RE: LP-24-24-00002, Nelson View  
I-90 Exit 74, West Nelson Siding Road, Vicinity

We have reviewed the proposed project and have the following comments.

**NELSON VIEW PLAT**  
A PORTION OF THE SOUTHEAST 1/4 OF SECTION 20,  
TOWNSHIP 20 NORTH, RANGE 14 EAST, W.M.,  
KITITITAS COUNTY, WASHINGTON

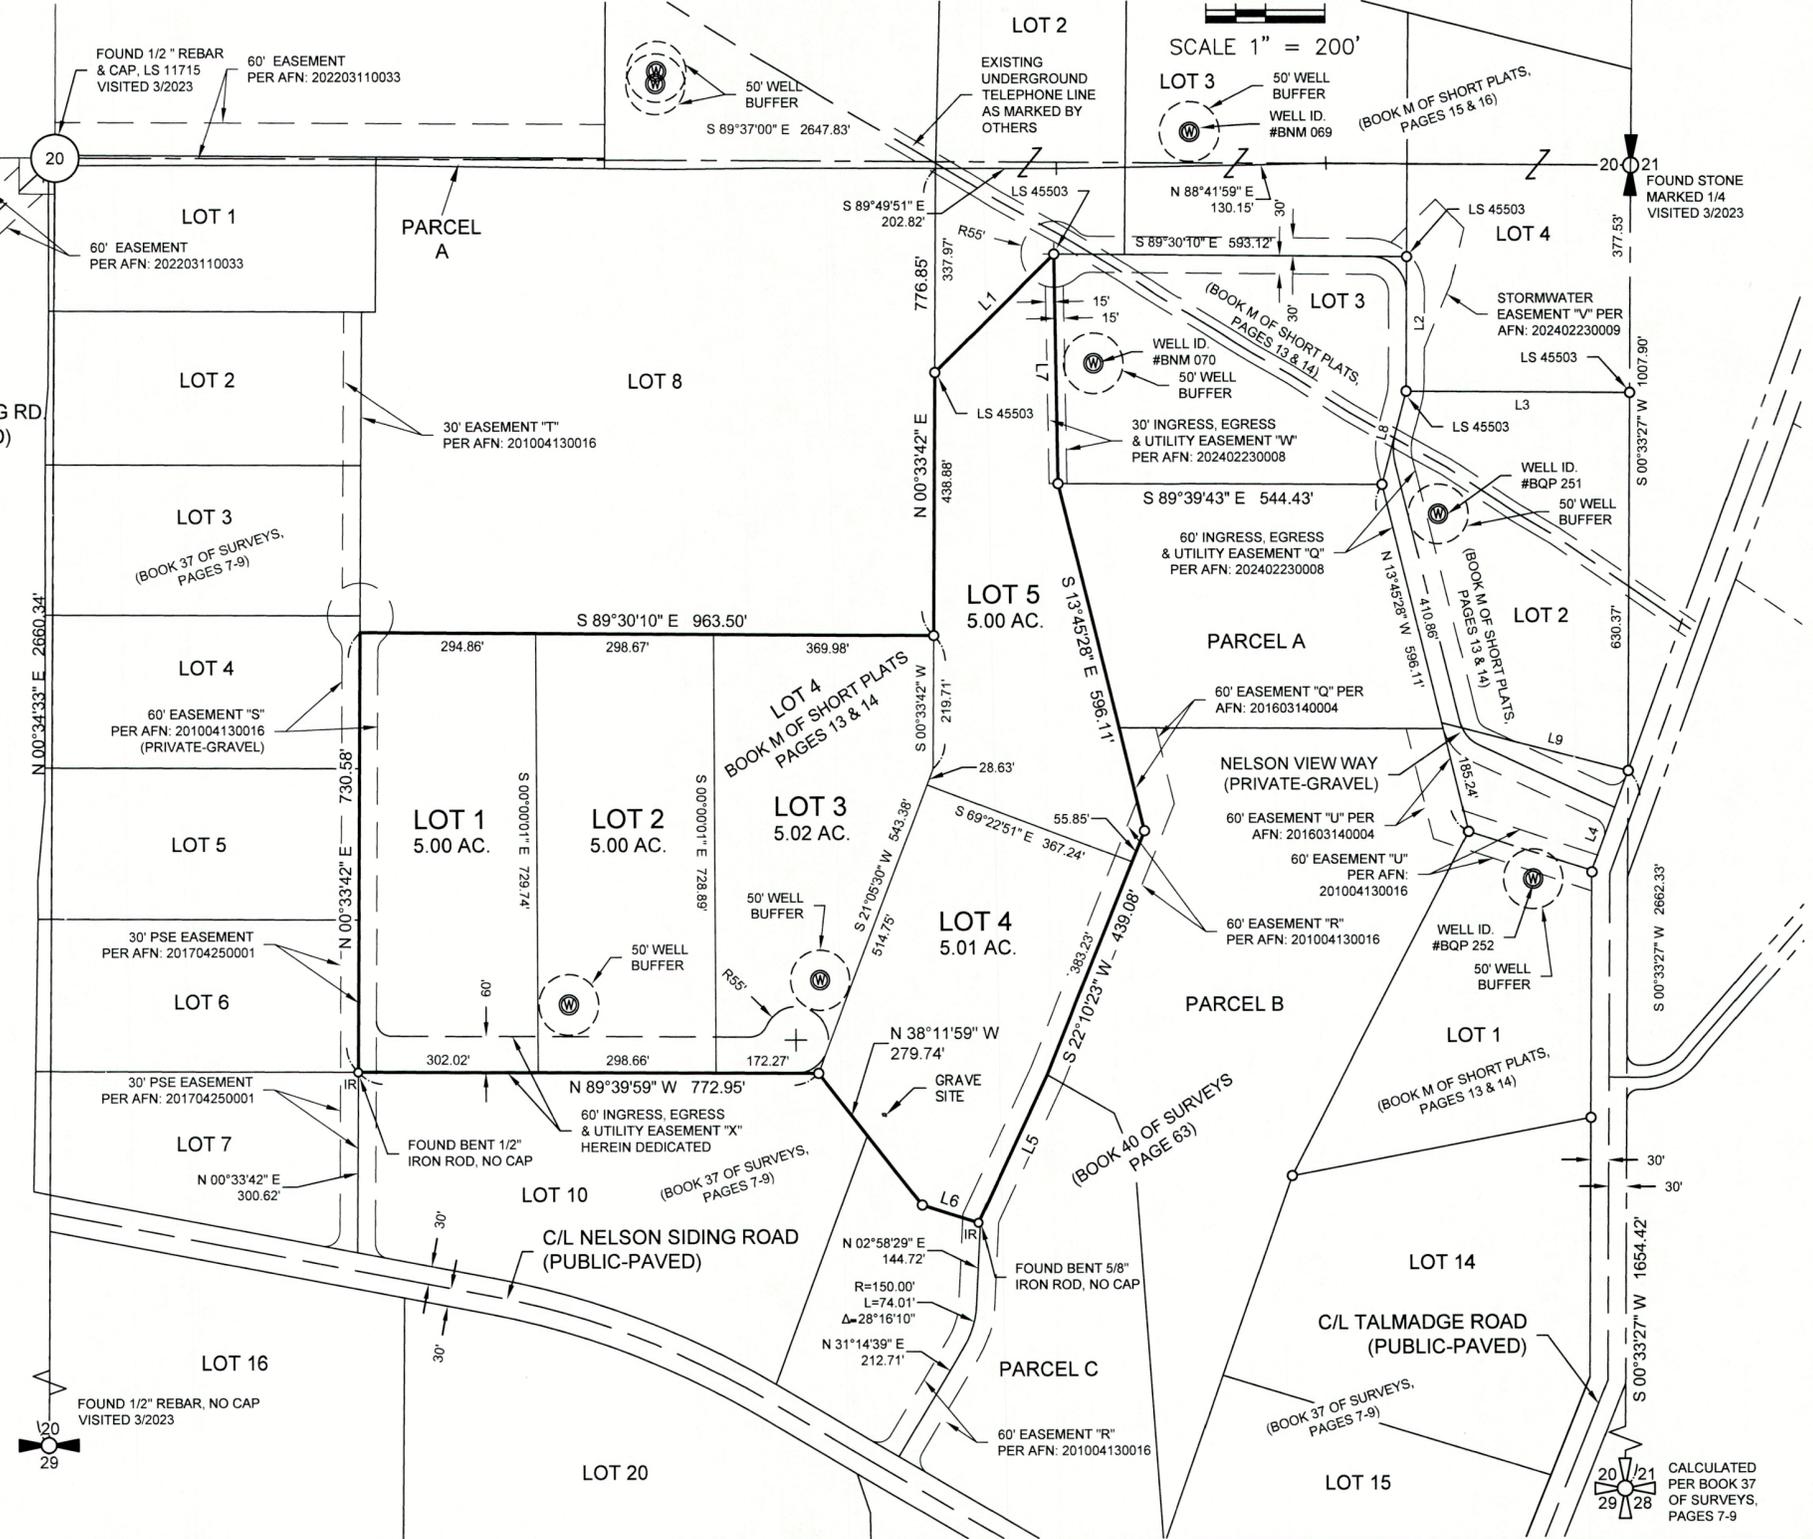
- The subject property is adjacent to Interstate 90 (I-90), a fully controlled limited access facility with a posted speed limit of 70 miles per hour. WSDOT has acquired all access rights to I-90. Direct access to the interstate is prohibited.
- I-90 is an existing facility, and the proponent is proposing a more noise-sensitive land use. The proponent and future residents should be aware this is an area with existing traffic noise. They should also expect traffic noise to continue to grow into the future, as an essential public facility, I-90 may need to be expanded to accommodate future traffic growth. It is the developer's responsibility to dampen or deflect any traffic noise for this development.
